**City of Sydney**

13 December 2010

**Jones Bay Wharf Marina Expansion 26-28 Pirrama Road, Pyrmont**

I refer to your request for comments on the current Part 3A Major Project application for the expansion of the Jones Bay Wharf Marina.

Figure 10 – Sketch showing location of proposed new public boardwalk

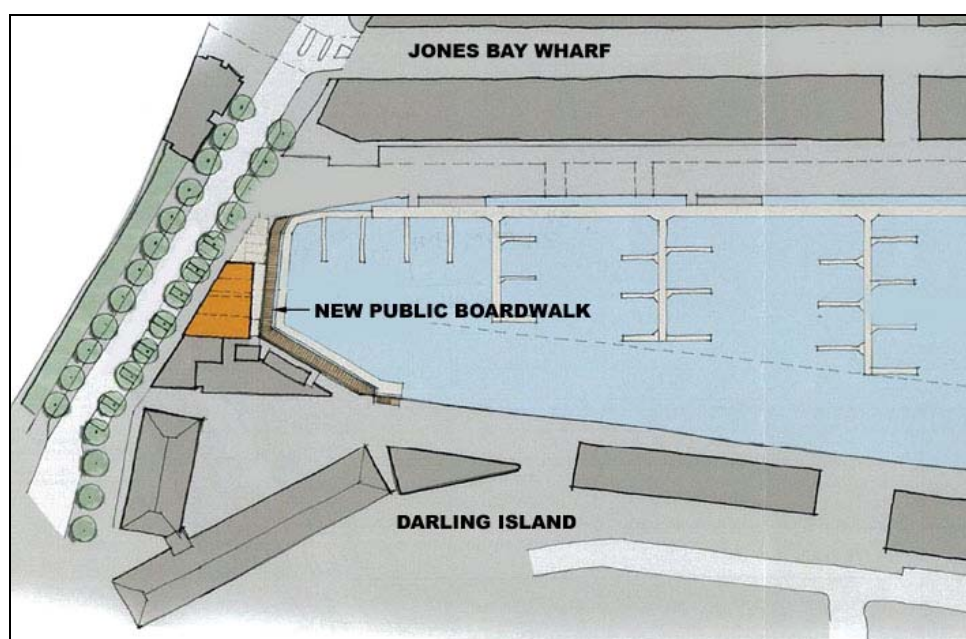
- To mitigate potential cumulative negative impacts of the proposal on views from the Jones Bay Wharf and to and from Sydney Harbour, the detailed design of the proposal should enhance the historical marine character of the existing heritage items.
- The proposed boardwalk should utilise hardwoods of large cross section area to providing a contrast with the concrete platforms around Darling Island.

- To mitigate the potential cumulative impacts of the proposal, a high level of design must be achieved to enhance the experience of the public in utilising the access way. This access should be maintained 24 hours a day.

The adjacent boardwalk identified in the planning assessment report is to be constructed as part of this project. Detailed plans, drawn to scale, by a suitably qualified consultant, must be submitted to and approved by Council prior to a Construction Certificate being issued. The plan must include:

- (i) Location of existing and proposed structures on the site including bulkheads and services (if applicable);
- (ii) Structural details including timber members, fixings and fittings, lighting and handrails (if applicable); and
- (iii) Impact on any heritage listed item such as existing wharf.

Certification of slip resistance, safety and accessibility of boardwalk by a suitably qualified access consultant is to be confirmed prior to Occupation Certificate being issued or the use commencing, whichever is earlier.
